Re: **Marysville Corporate Center – BSP (PA22004)**
3rd Round Response Letter
Project Number 2200444.00

In response to your plan review checklist dated January 10, 2023, we have addressed the items below, with our responses following your comments.

PROPOSED IMPROVEMENT

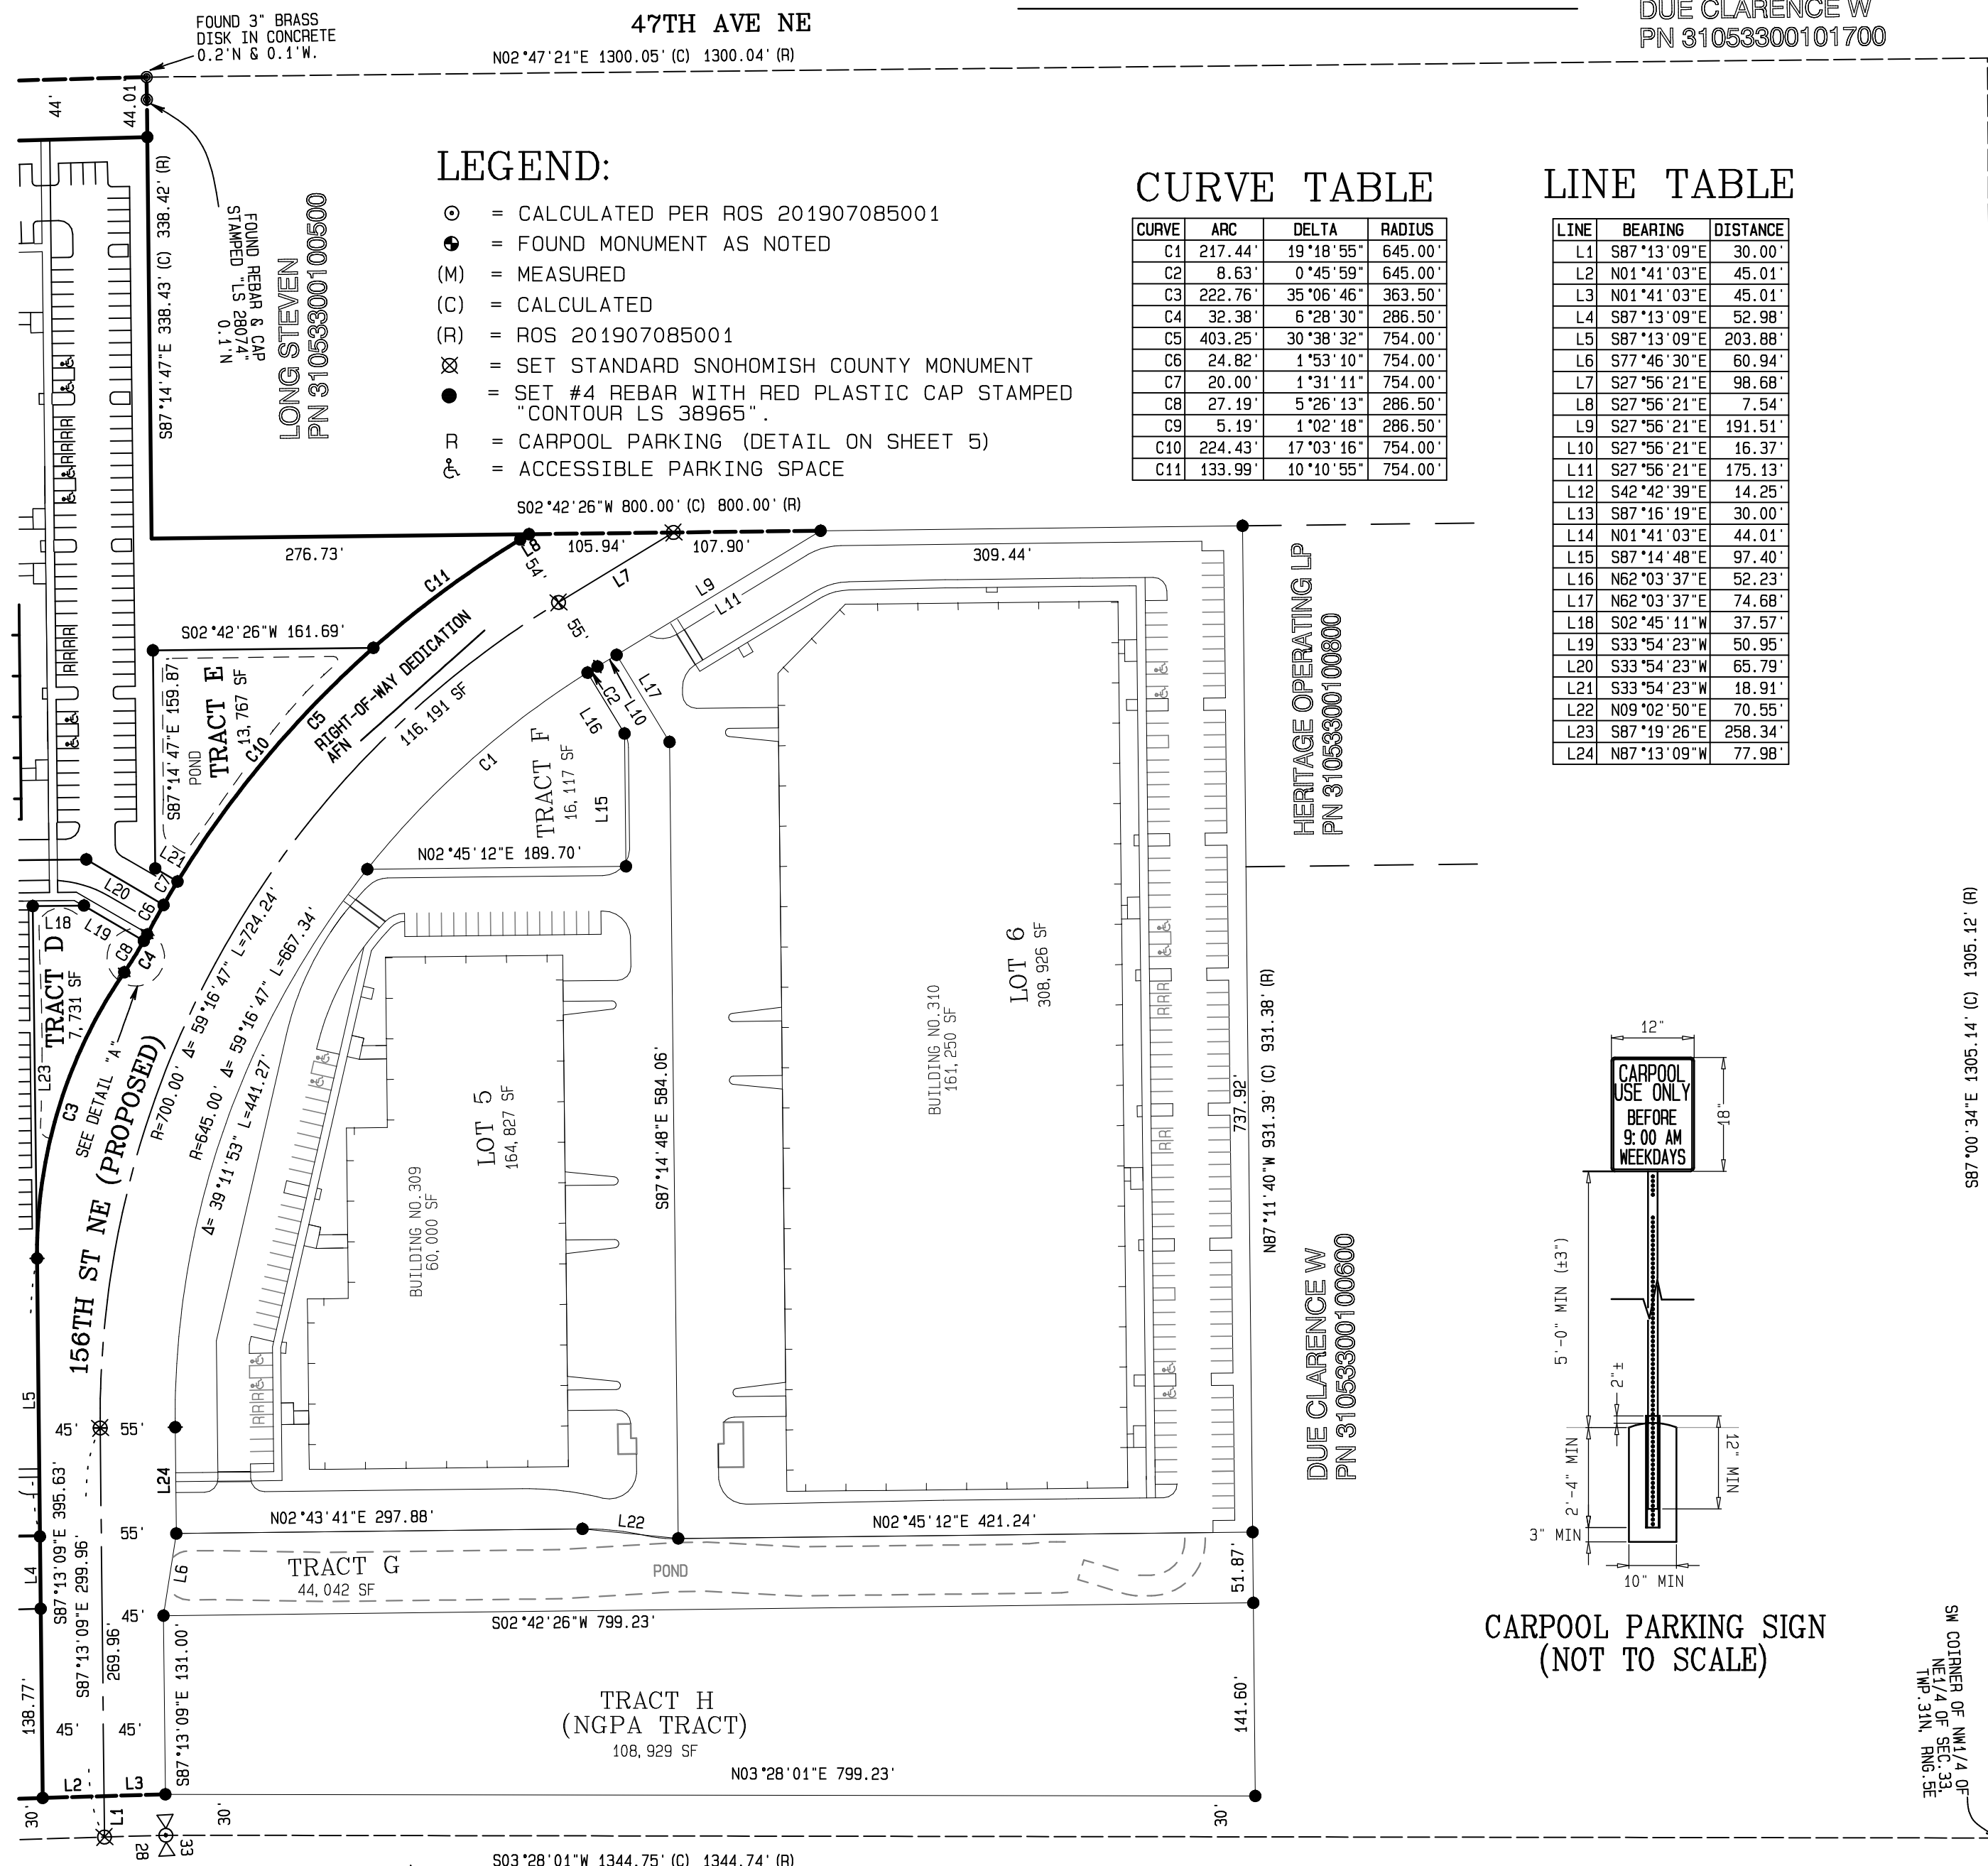
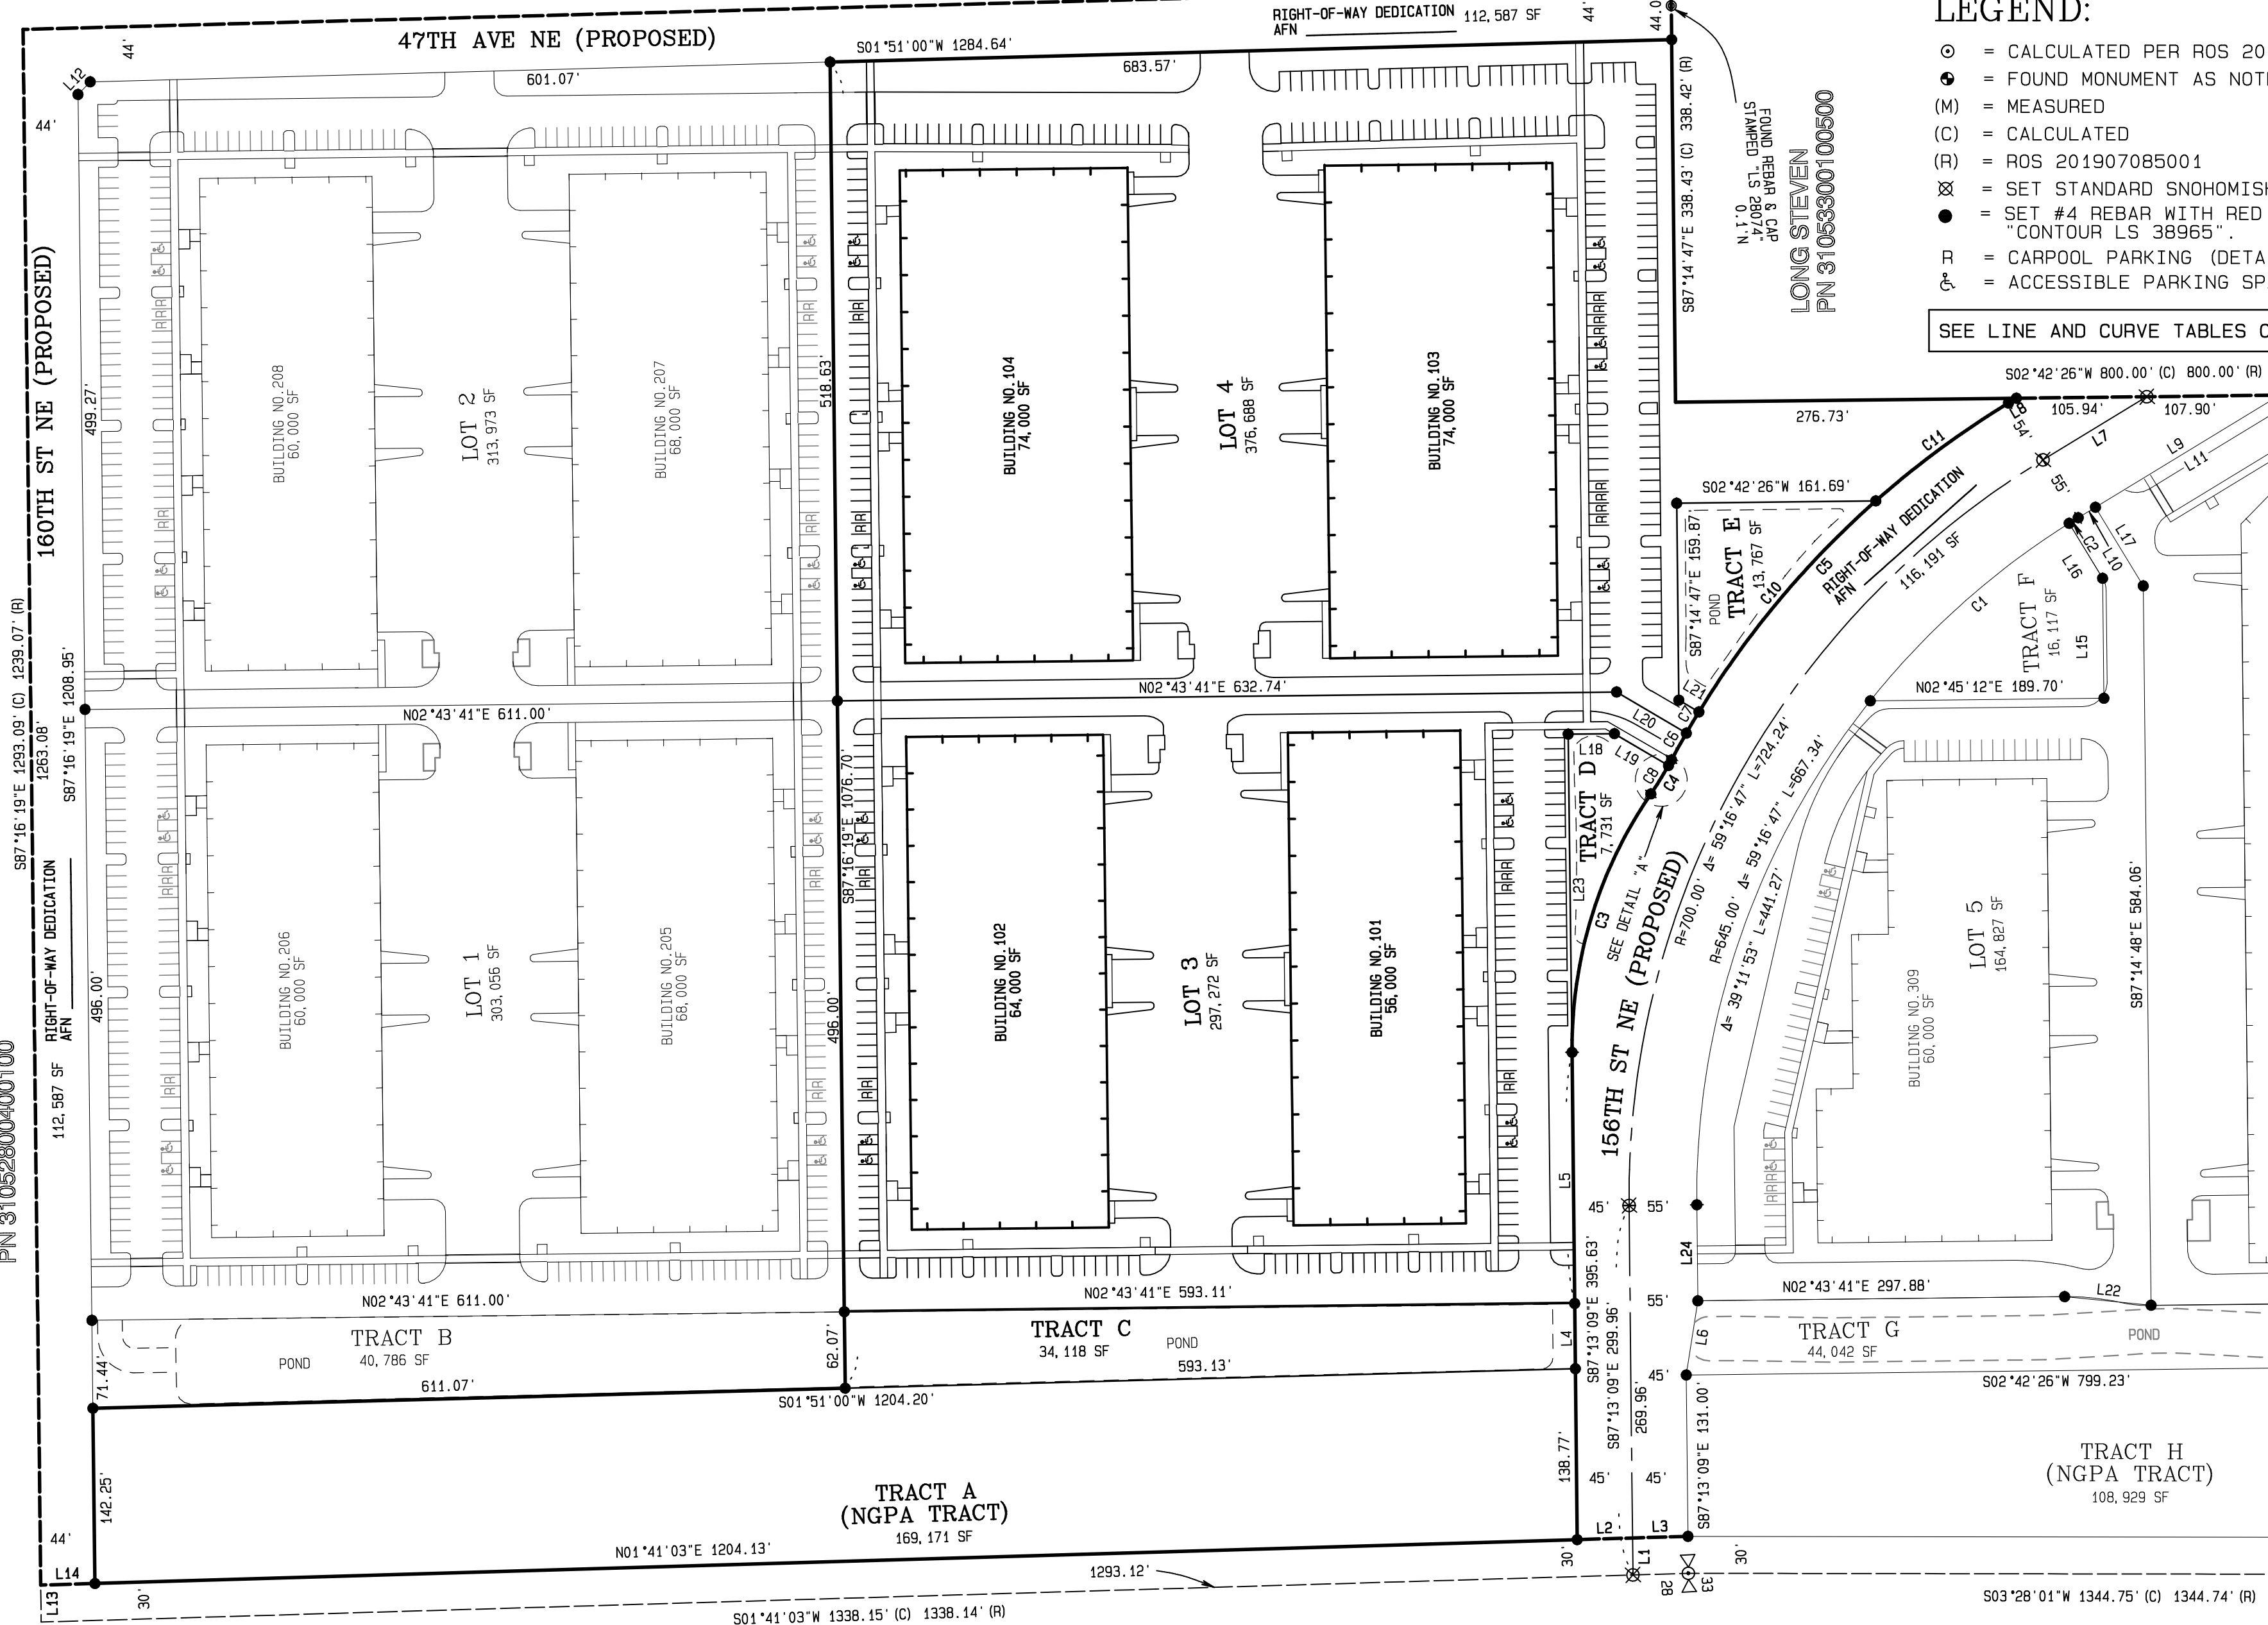
1. *The proposed Lot Numbers go from Lots 1 – 6, skip Lot 7, and include Lots 8 & 9. Lot numbers will need to be amended to be consecutive.*

2. *Amend Lot numbers so they are successive from top to bottom.*

3. *Are Lots 8 & 9 storm facilities? If so, they will need to be referenced as Tracts and not Lots.*

4. *Amend Tracts B-1 & B-2 to have their own individual letter and omit the number.*

5. *Tracts A & D are Natural Growth Protection Areas Tracts (NGPA) and will need to be labeled, as such.*

Response: The revised BSP reflects lot numbered consecutively.

Response: The revised BSP reflects lot numbers successive from top to bottom.

Response: A portion of lot 8 (now lot 7) contains a storm pond which is designated tract E; the remaining portion will be a part of lot 4. Lot 9 is now Tract F (Future Development Tract).

Response: Tracts B-1 and B-2 have been renamed Tract B and C.

Response: Tracts A and D have NGPA designations shown on the BSP.
